## Application for non-material amendment following a grant of planning permission

First Floor Extension above existing garage

23/01513/HSE

Amended external finish from brick to hung tiles & render

1 Proposed Front Elevation
1 : 100

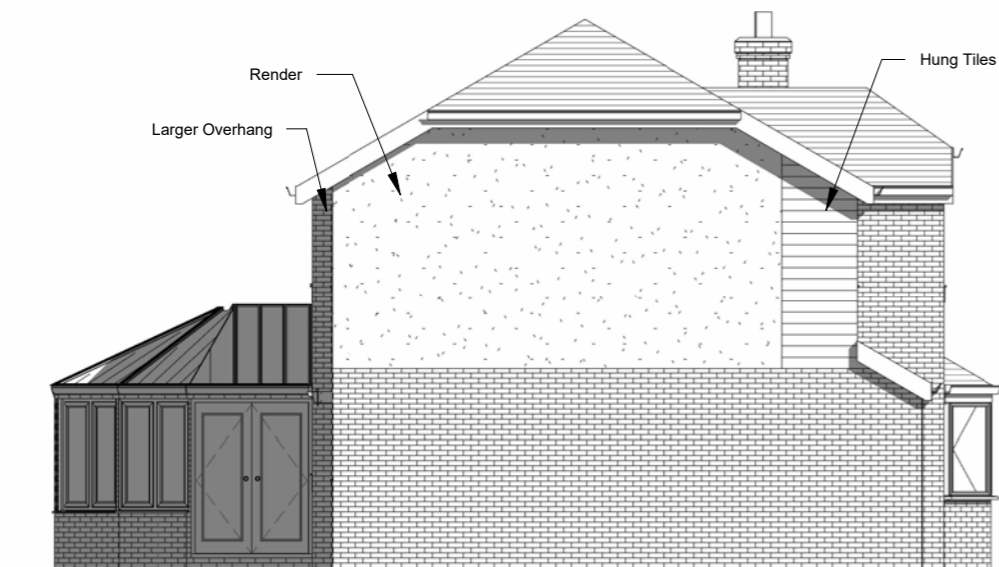
Unable to match existing brick
